**City of Portland, Maine - Building or Use Permit Application**

Permit No: 04-0866	Issue Date:	CBL: 425 I004001
-----------------------	-------------	---------------------

<b>Proposed Use:</b> warehouse with 9865 sq ft addition	<b>Proposed Project Description:</b> build 9865 sq ft addition to warehouse. Metal roof & walls, fencing, landscaping
--	--

RE: C. of O. for the 142 Presumpscot Street - Warehouse addition  
Coastal Equipment (CBL425I004) (ID 2003-0104)

142 Pennington St
 RAILINGS
 YGSI Y

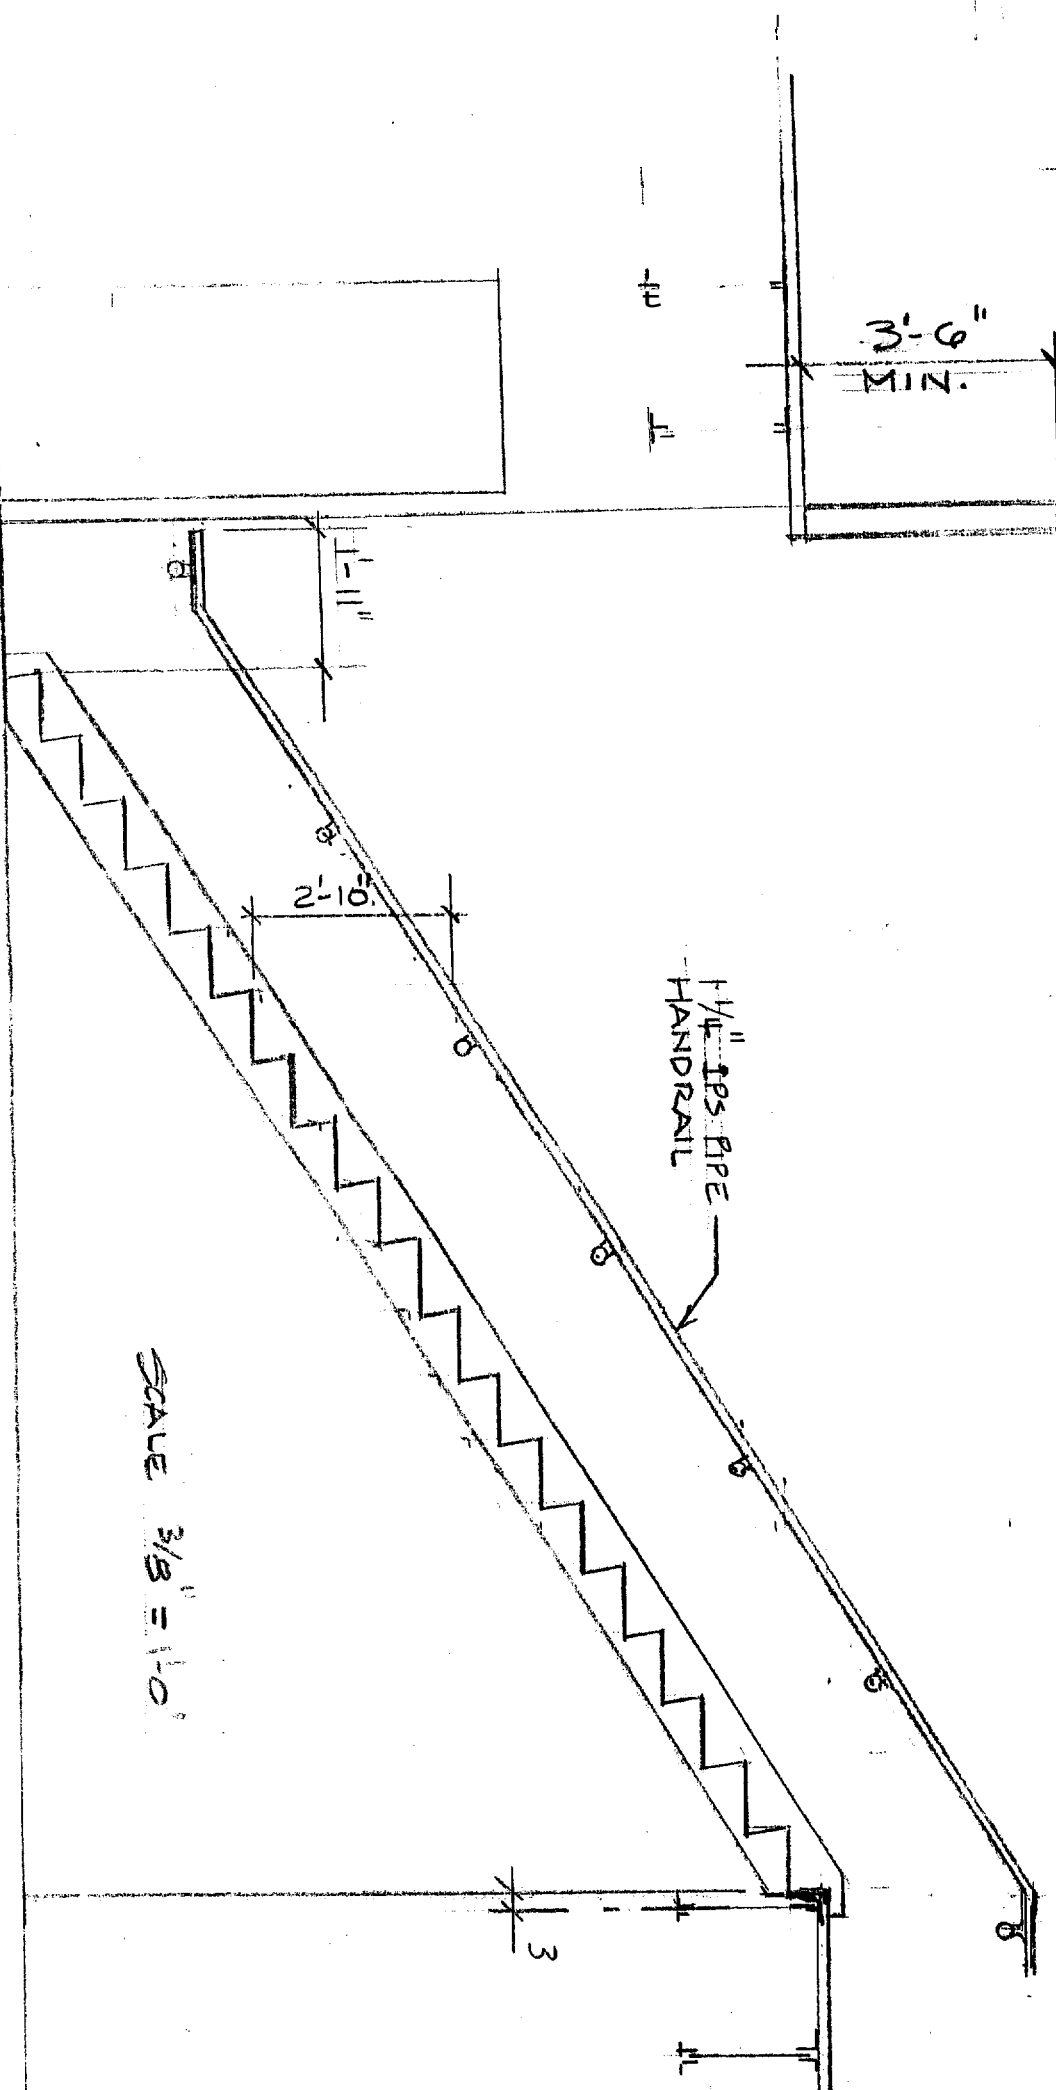
<b>Dept:</b> Building	<b>Status:</b> Approved with Conditions	<b>Reviewer:</b> Mike Nugent	<b>Approval Date:</b> 09/16/2004
<b>Note:</b>			<b>Ok to Issue:</b> <input checked="" type="checkbox"/>
<p>1) Must provide reinforcement plan for masonry fire wall prior to construction All guards must be 42 inches in height. The roof of the existing building must be evaluated for drift loads from addition.</p>
